MP-2006/209/C

6 September 2011

Proposed modifications to concept plan and a project application for:

I refer to your correspondence dated 5 August 2011 requesting comment in regard to the GPT Group's request to modify the above project pursuant to Section 75W of the Environmental Planning and Assessment Act 1979. Council has reviewed the proposal and provides the following comments on the modified conditions sought:

Figure 3-2: Modified access to basement car park

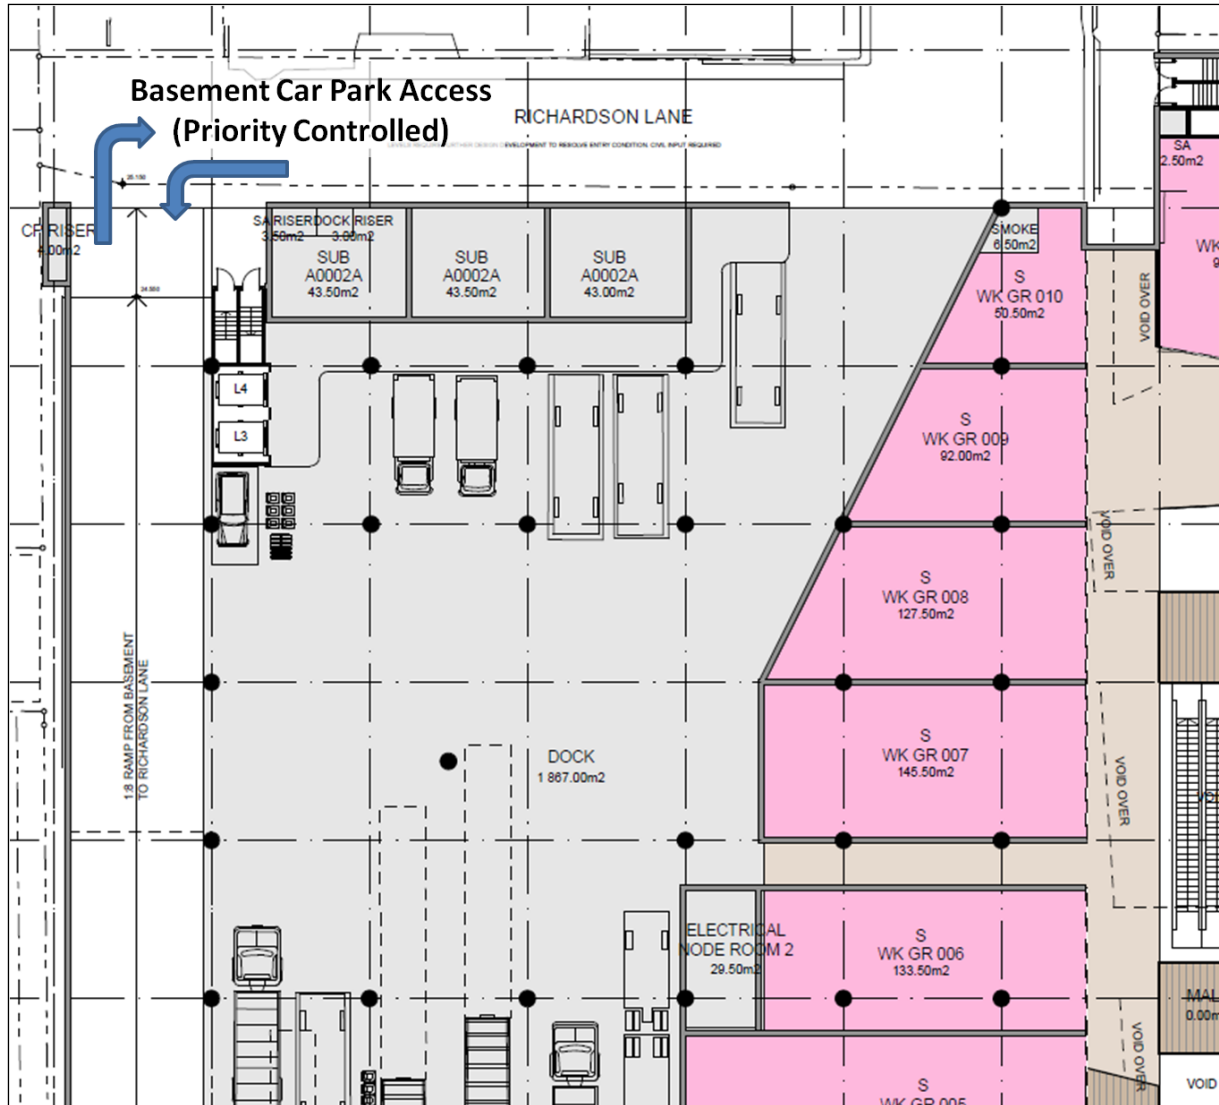
- The proposed modification will increase traffic volumes on Richardson Lane significantly and the current road width will not safely cater for the proposed two way traffic volumes. Council recommends that the widening and reconstruction of Richardson Lane in accordance with Austroads Guide to Road Design be included within the required list of traffic management works as stipulated in condition of consent condition B18.

- The car park driveway entry in Richardson Lane should allow for passing of vehicles simultaneously entering and exiting the ramp.
- The fragmented nature of the proposed car parks will likely result in additional vehicle circulation on surrounding streets. This will have a significant impact on the operation of the road network. Council recommends that either the internal layout be modified to provide connected car park levels within the West Keira building or a parking guidance system be provided on street and within the car parks to inform route choice and improve general car park operation thereby reducing vehicle circulation on street. This parking guidance system should provide drivers with real time information on parking availability within each car park and include signage for the Crown Central Keira/Kenny Street car park as well as the Crown Central Market Street and West Keira Development sites. This work should be completed in coordination with Council and the RTA to enable the provision of such signage at key intersections in the surrounding road network.

- The deletion of the roundabout from the proposal will remove a turn around opportunity at this location. Council recommends that the design should be revised to provide a turn around facility for vehicles which enter Richardson Street but do not wish to then enter the car park or the loading dock.

Figure 3-5: Modified access to loading dock

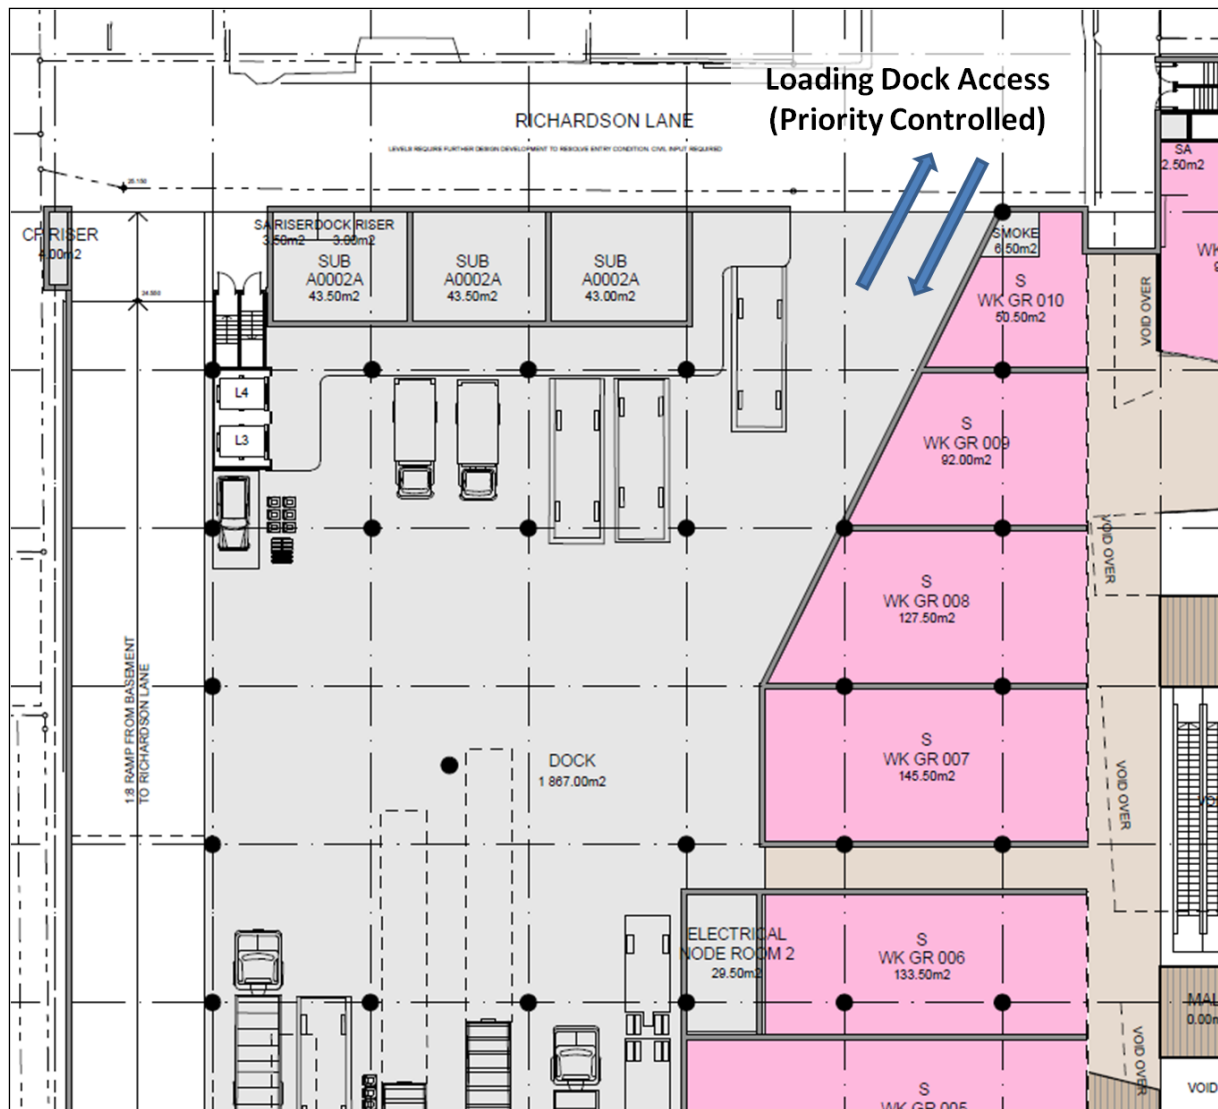
- The impacts of turning movements (of the proposed 19m design vehicle) for the Market Street and Richardson Street intersection have not been assessed as the documentation does not contain information relating to turning paths. Council recommends that turning movements comply with relevant standards.
